PINS project reference: WS010005

16 June 2022

East Northants Resource Management Facility Western Extension

Request for a Non-Material Change

Figure ESA5.1 Scale: 1:2,500@A2

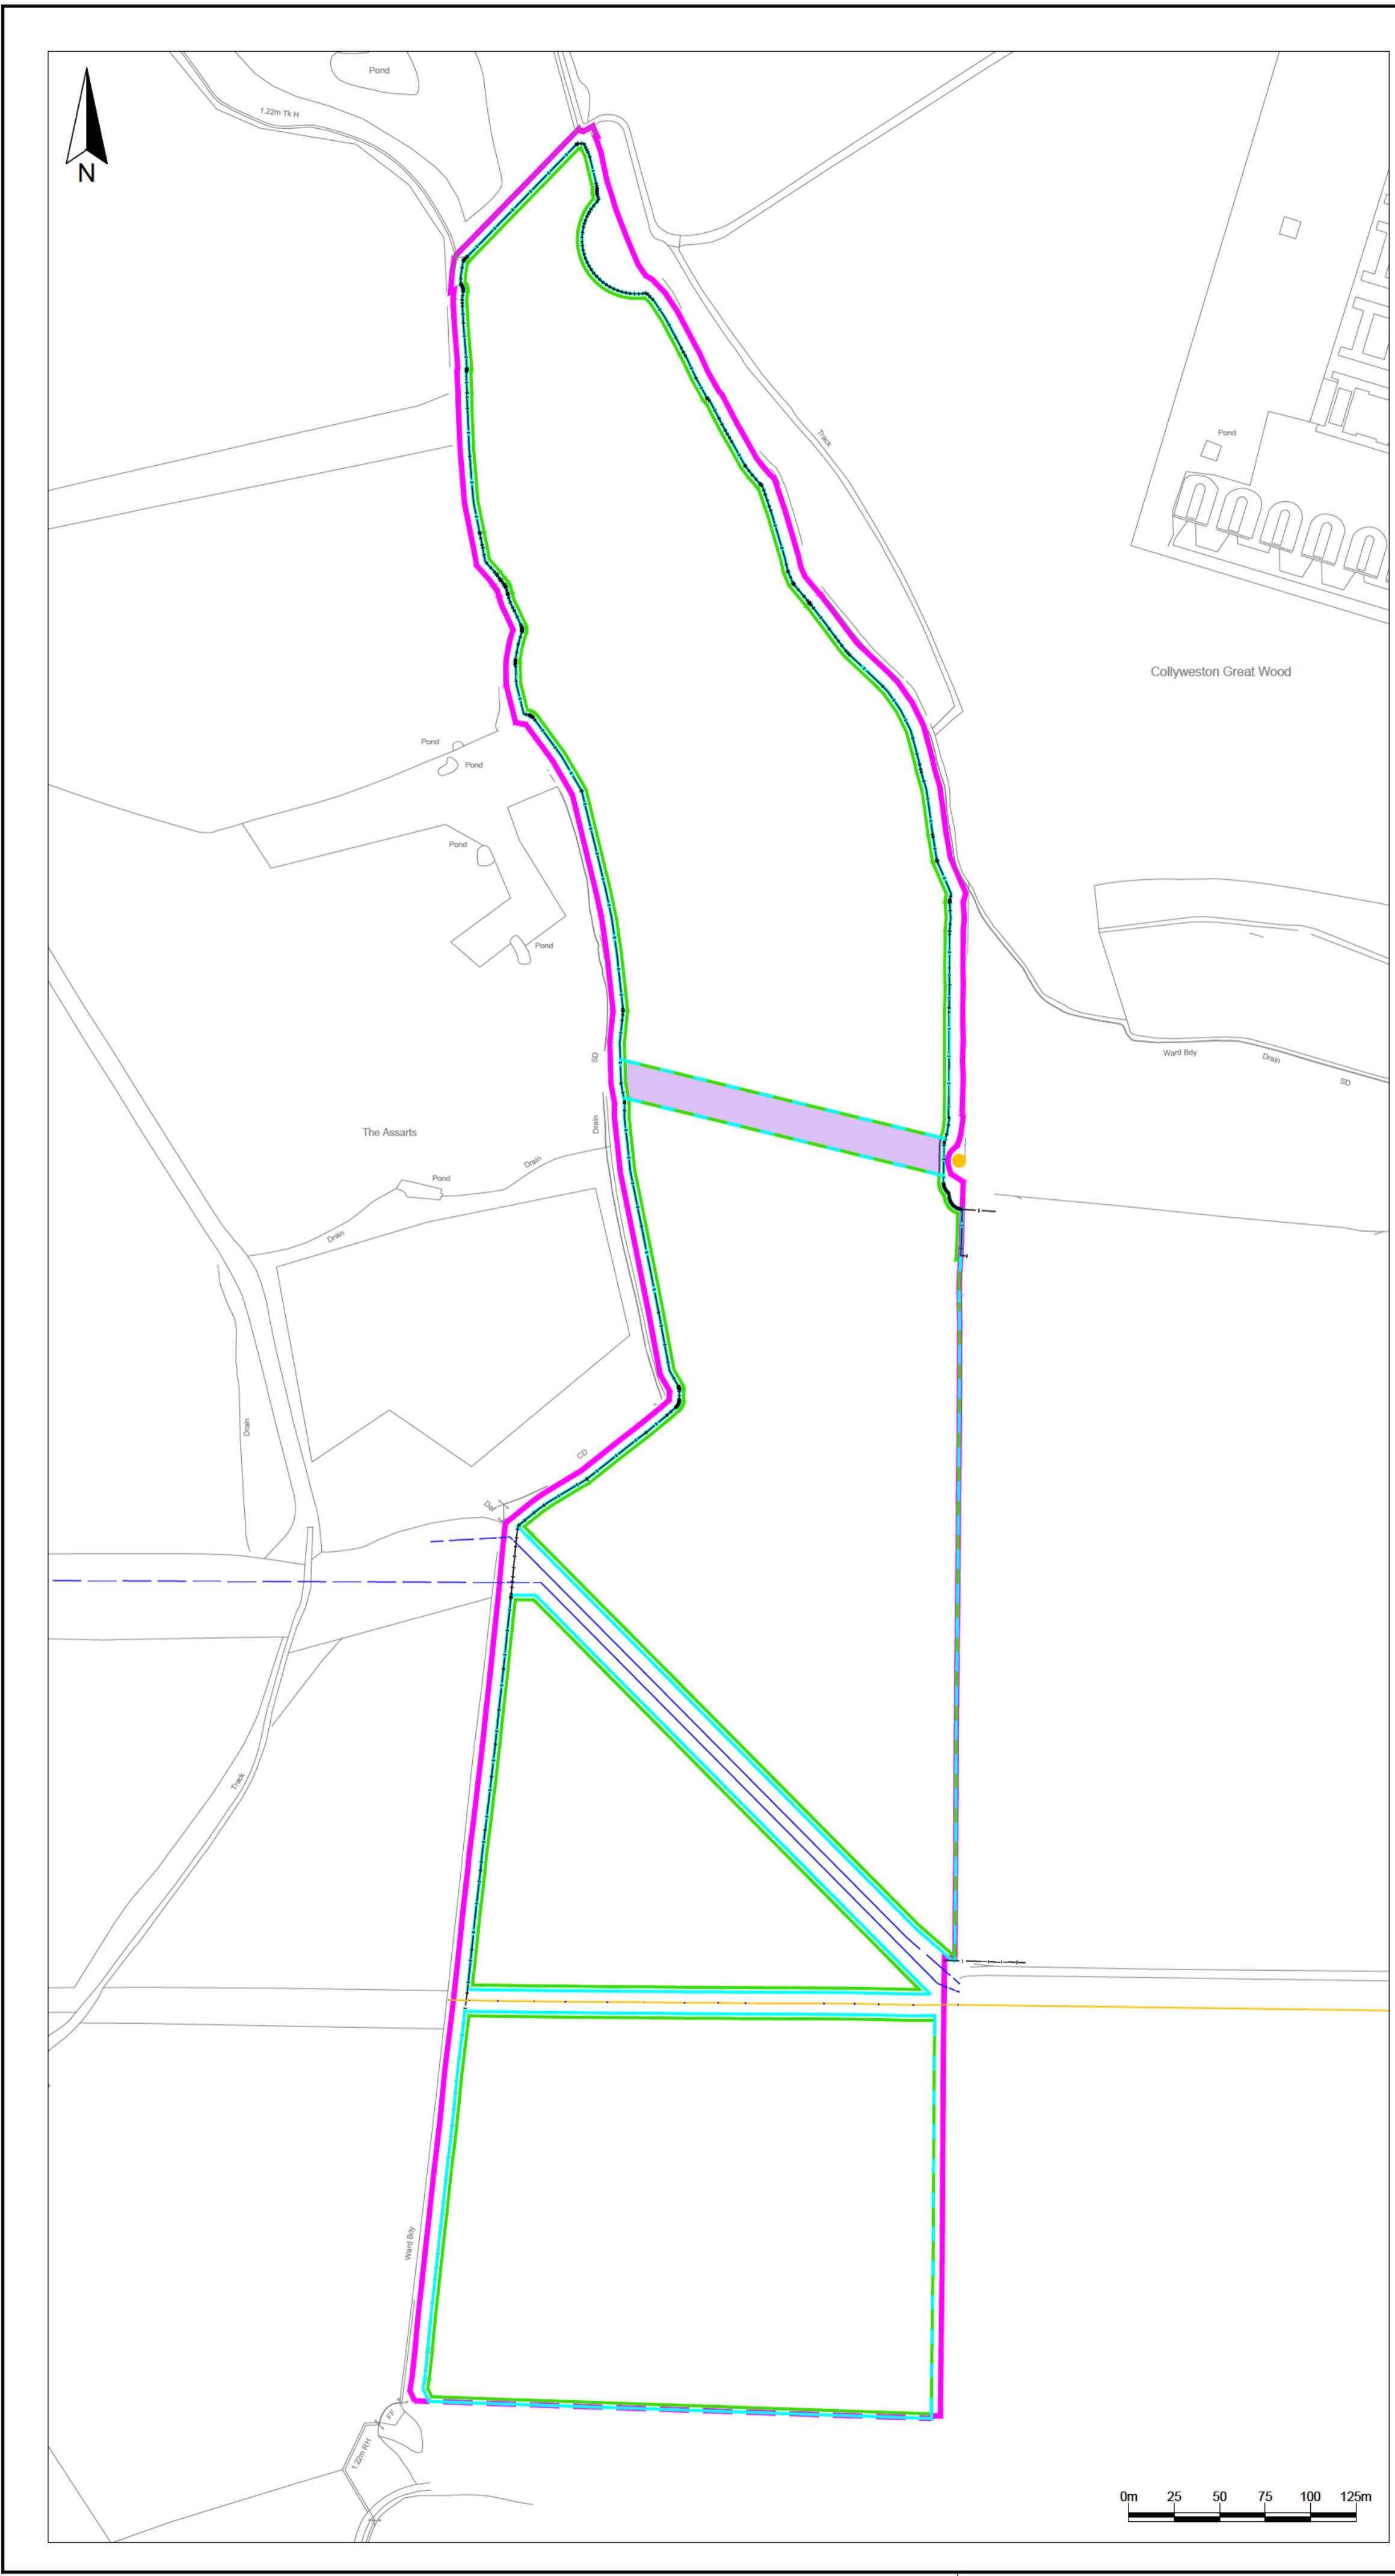
- 2.5 Appendix DEC B (boundary principles) of the DEC (**APP-110**) has been updated to show a range of 7 to 30 metres for the water pipe standoff and wording has been included to clarify that the types of protection fencing necessary will be finalised in the phasing, landscaping and restoration scheme. This is because the standoff distance may impact the types of protection fencing required due to the species present at the time of construction. The plan in Appendix DEC C has also been updated to show the revised Works Plan layout.
